Tweed Valley Hospital Development

Addendum 2 to Design Report

Issued for: State Significant Development Application – Response to Submissions

130559-BON-CIV-RPT-007

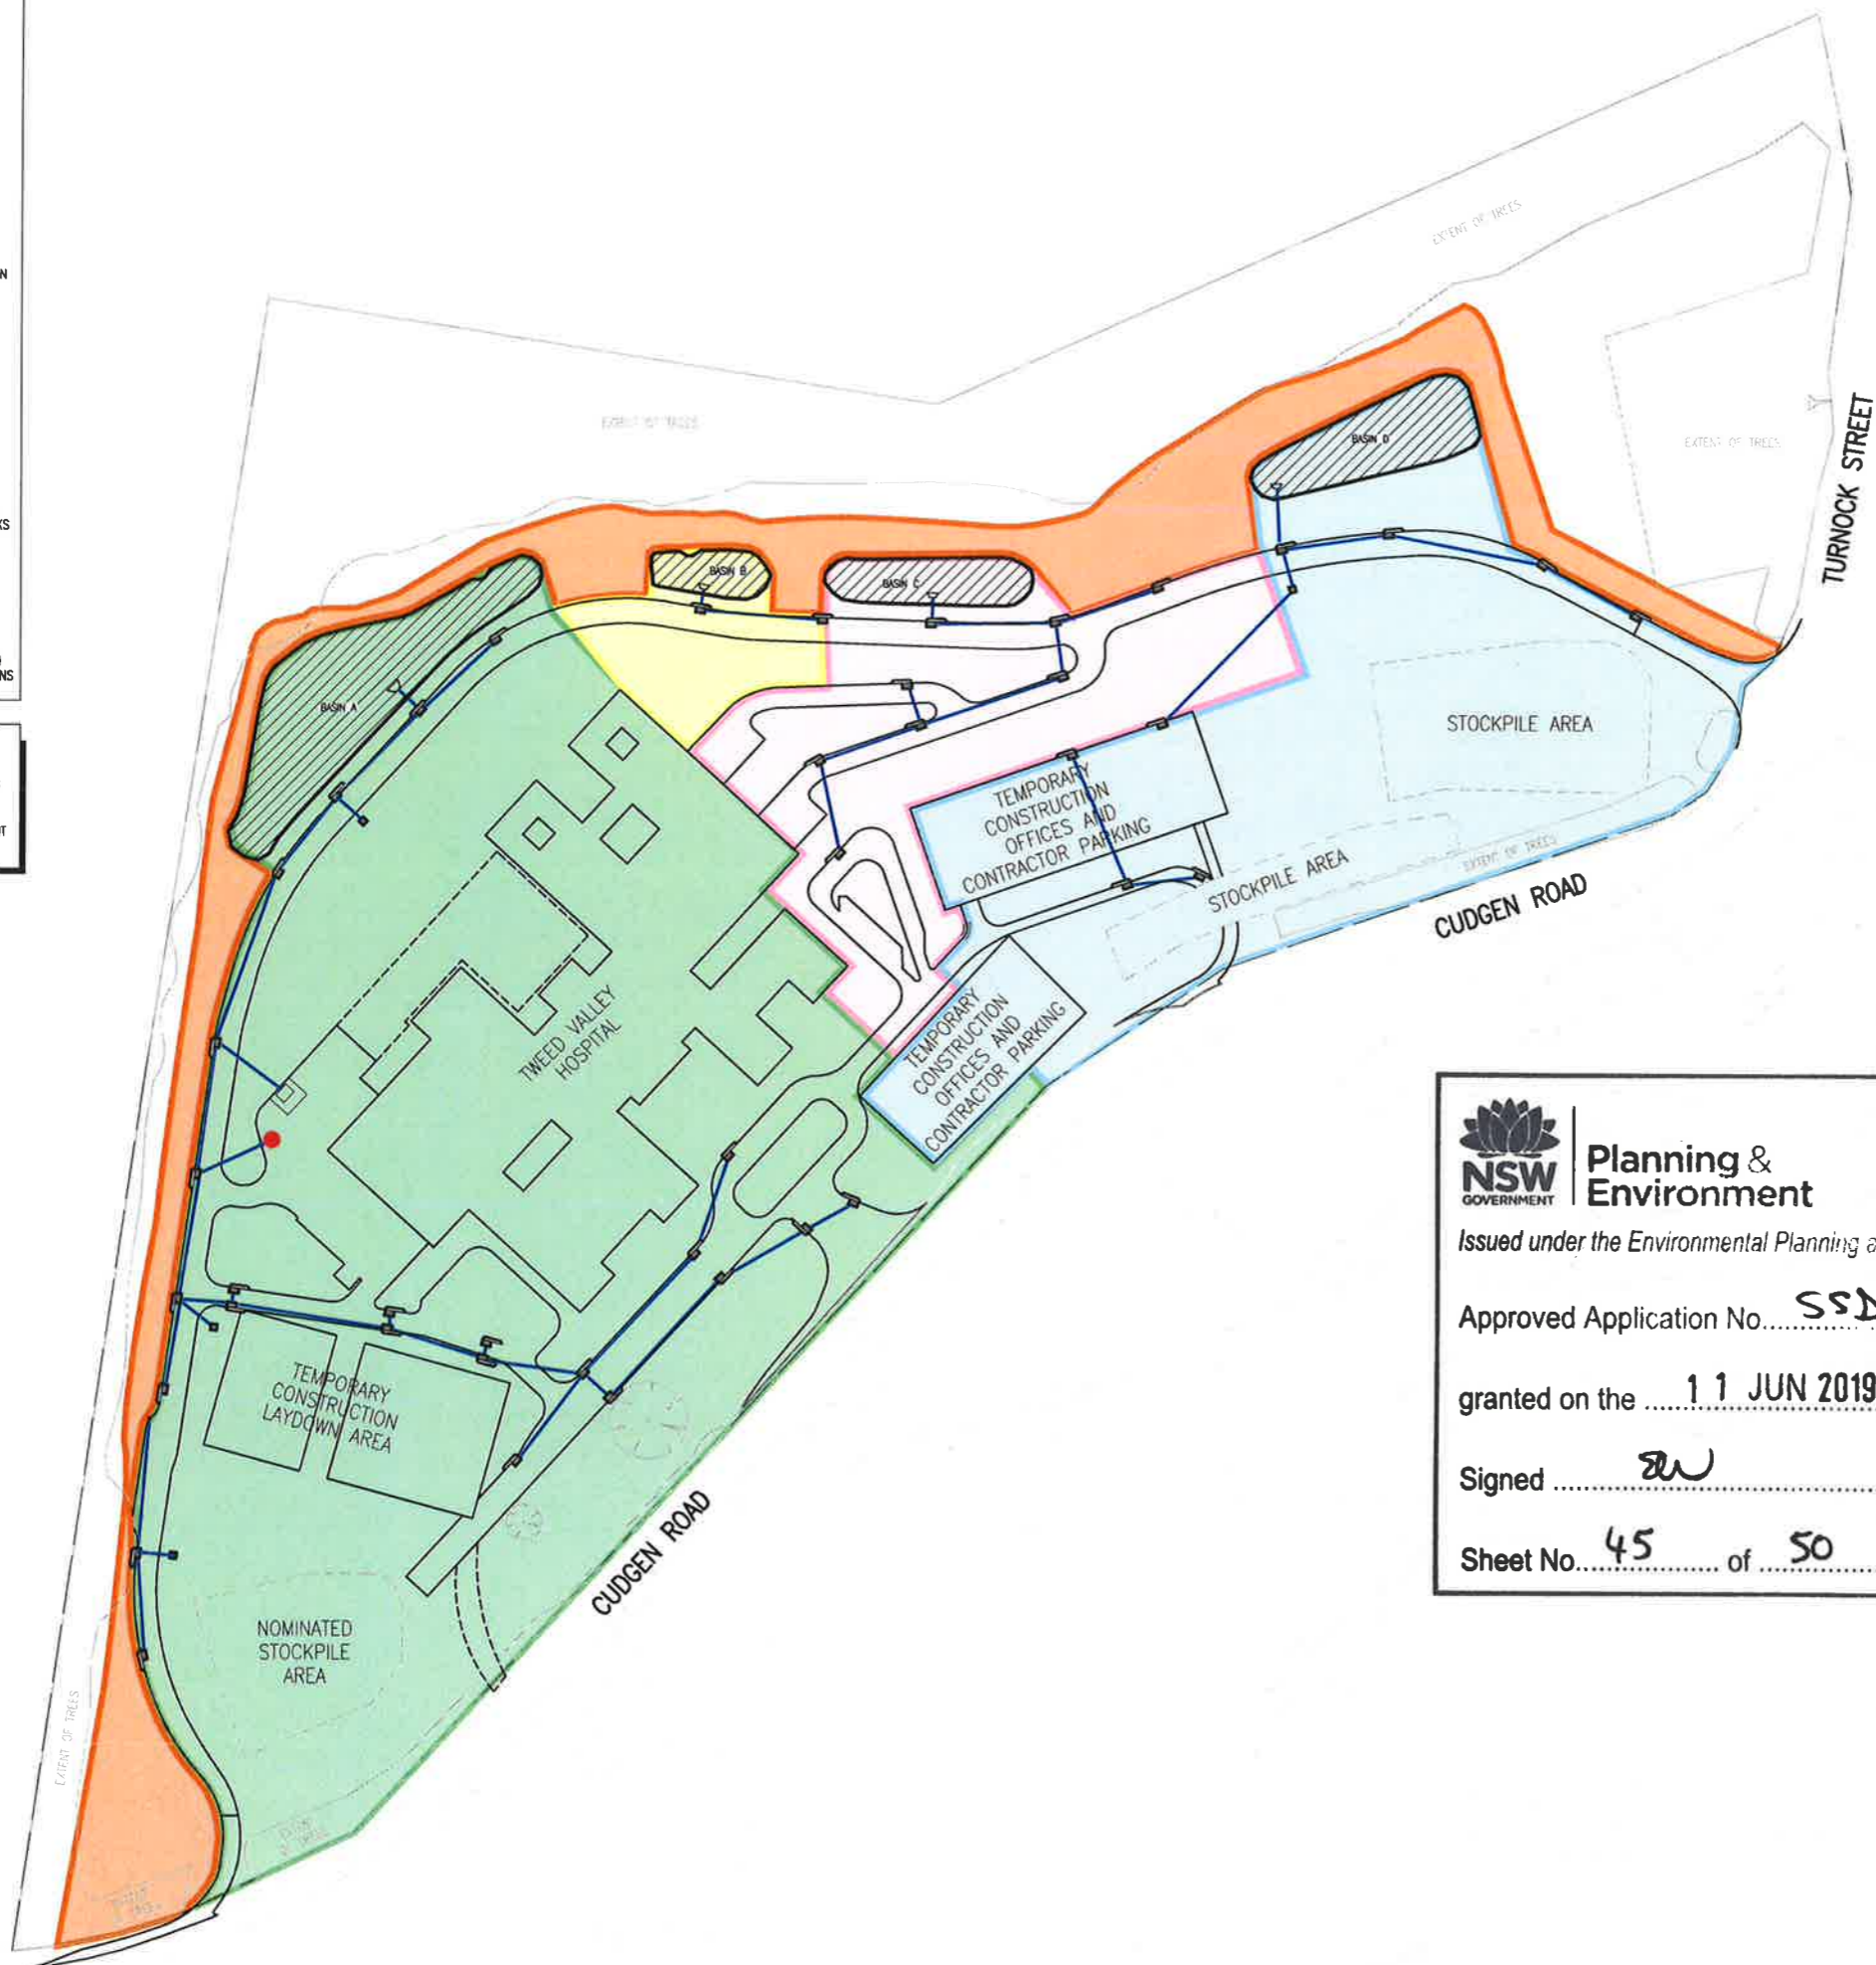
The Design report states that the stormwater would drain into a bio-filtration swell and then discharge into the wetlands. However, the plans for the strategy indicate that stormwater treated through bioretention swales and basins would be discharged into the detention basins that function as dry sediment basins for water quality purposes.

This is likely to result in the treated water being mixed with sediment deposited in the basin and this would lower the runoff quality. Stormwater treated through bioretention should bypass the detention basins. This bypass flow should be accounted for when finalising the detention basin design. Notwithstanding that this can be considered in detail at a later stage, the discrepancies in the plans and reports should be addressed.

The required area of bio-retention (as single treatment measure) to treat the site in accordance with requirements is 2,000m² (800 m² of filter media area is required as shown in the MUSIC model). It is proposed to utilise bio-retention basins. The basins at the north of the site have significantly more area than that required for bio-retention, with almost 3000 m² of basin base area available. The bio-retention area could be separated from the deeper detention area in the basins, and allowed to spill into the detention area once the maximum extended detention depth was reached. The subsurface underdrain pipes that convey the treated flows from the bio-retention would be connected to the outlet pit in the detention basin, and would bypass the detention storage as noted by DPE. Note that the bio-retention area required will be reduced as the MUSIC model is developed in conjunction with the architectural layout, as Enviropods and Puraceptors etc are utilised. This is subject to detailed design. Note that the MUSIC model was only produced to demonstrate that the development was feasible (and able to meet water quality targets).

Designed	PA	Project Director Approved	Date	North
Drawn	PA			
Scale	1:1250	Project Ref	Drawing No	Rev
Date	03.09.18	20 10748 01	C030	P6
Sheet	A1

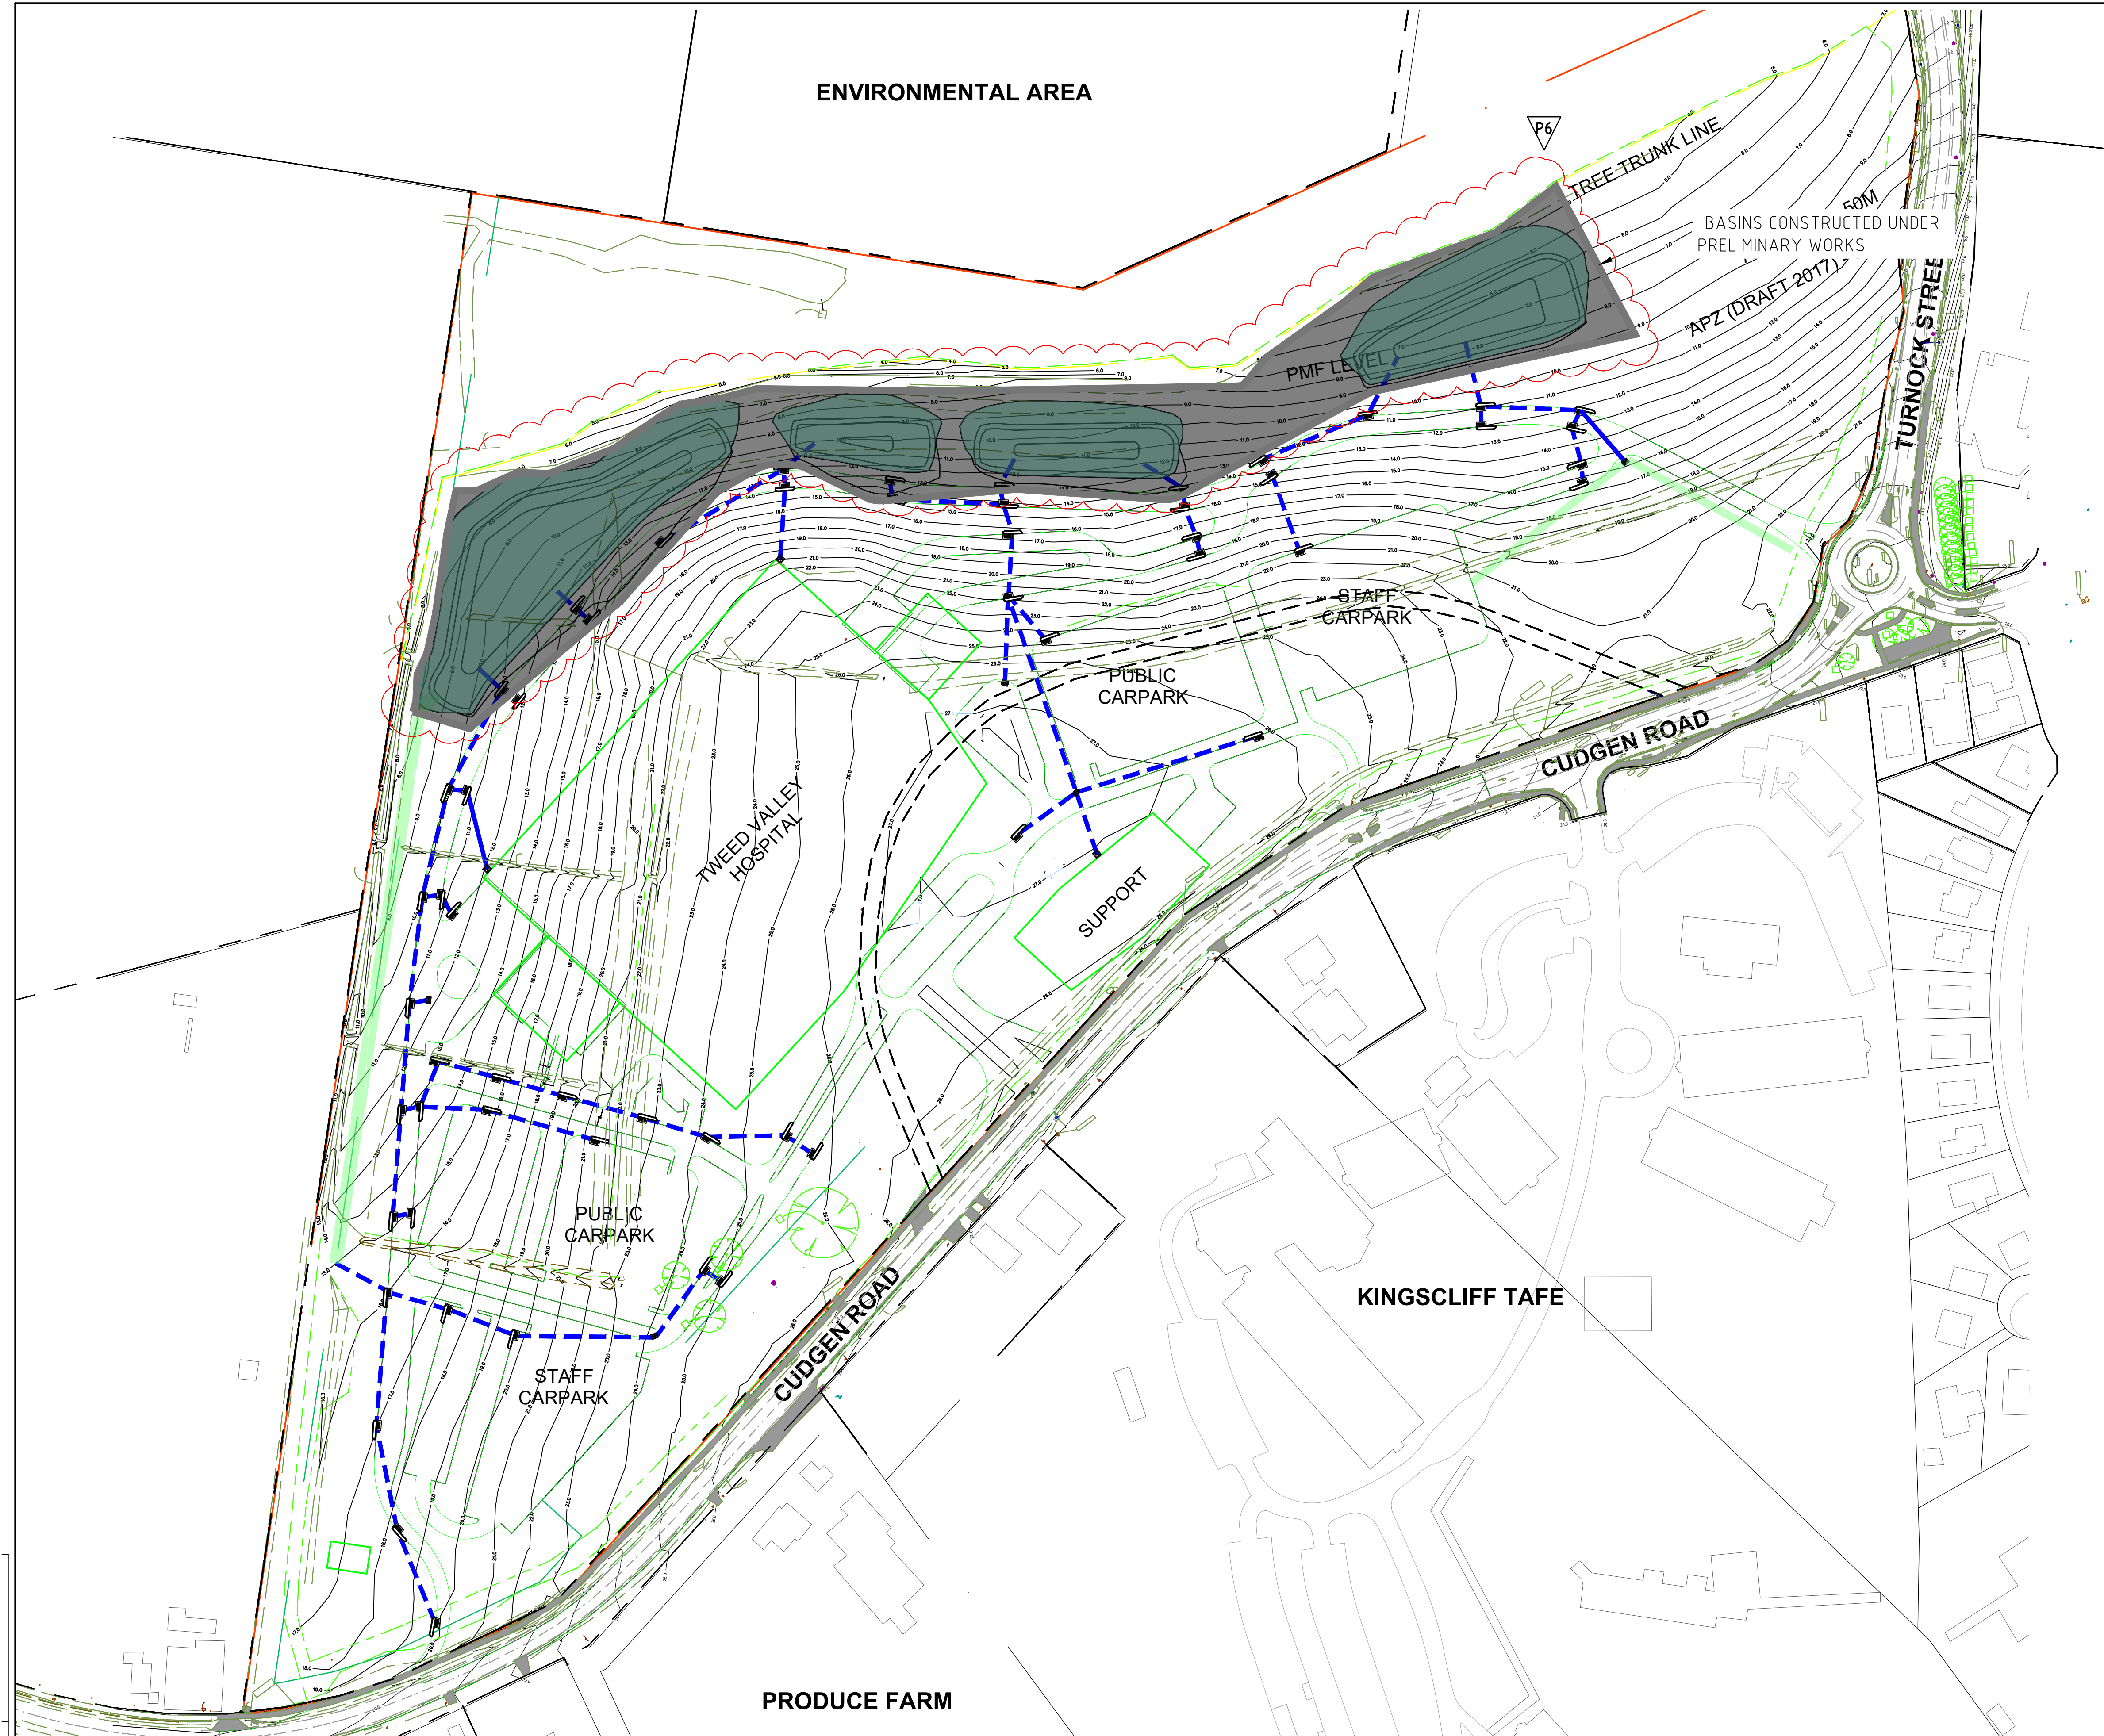
Treatment nodes – The post development model indicates that the extended detention depth in the bioretention swale would be 0.9m. The drawings indicate that biofiltration measures would have an extended detention depth of 0.15 to 0.5m. Typically, this depth should be around 0.3m maximum for a swale, and 0.6m for a bioretention basin to minimise the time vegetation would be inundated. The dimensions modelled should be adjusted to reflect what is proposed.

Model configuration - The configuration of the treatment nodes in the model does not align with the concept outlined in the Design Report (i.e. Enviropods, swales, bioretention basin and detention basin) and on the drawings. The MUSIC model only includes one bioretention treatment node.

- The bio-retention basin extended detention depth has been updated (it was initially considered that the bio-retention would be incorporated in the detention basins – actual detail of this would be determined during detailed design, but depth could have been up to 0.9m, as this is what was modelled in DRAINS for water peak flows). The bio-retention area could be separated from the deeper detention area in the basins, and allowed to spill into the detention area once the maximum extended detention depth was reached. The subsurface underdrain pipes that convey the treated flows from the bio-retention would be connected to the outlet pit in the detention basin. Data for this model run is attached. The MUSIC model sqz file has also been provided.

Additional treatment measures will also be provided – they will most likely include Enviropods (treating runoff from carparks and roads prior to discharge to bio-retention) and will include a Puraceptor or equiva(which will be required for the Helipad that is likely to be located on the roof). These treatment measures were not included in the model, as the progression of the architectural design has not advanced to a stage where the catchment areas draining to these measures is known. These additional treatment measures would provide higher rates of pollutant removal, which may allow reduction in bio-retention area provided (to be determined during further detailed design). The MUSIC model sqz file has been provided.
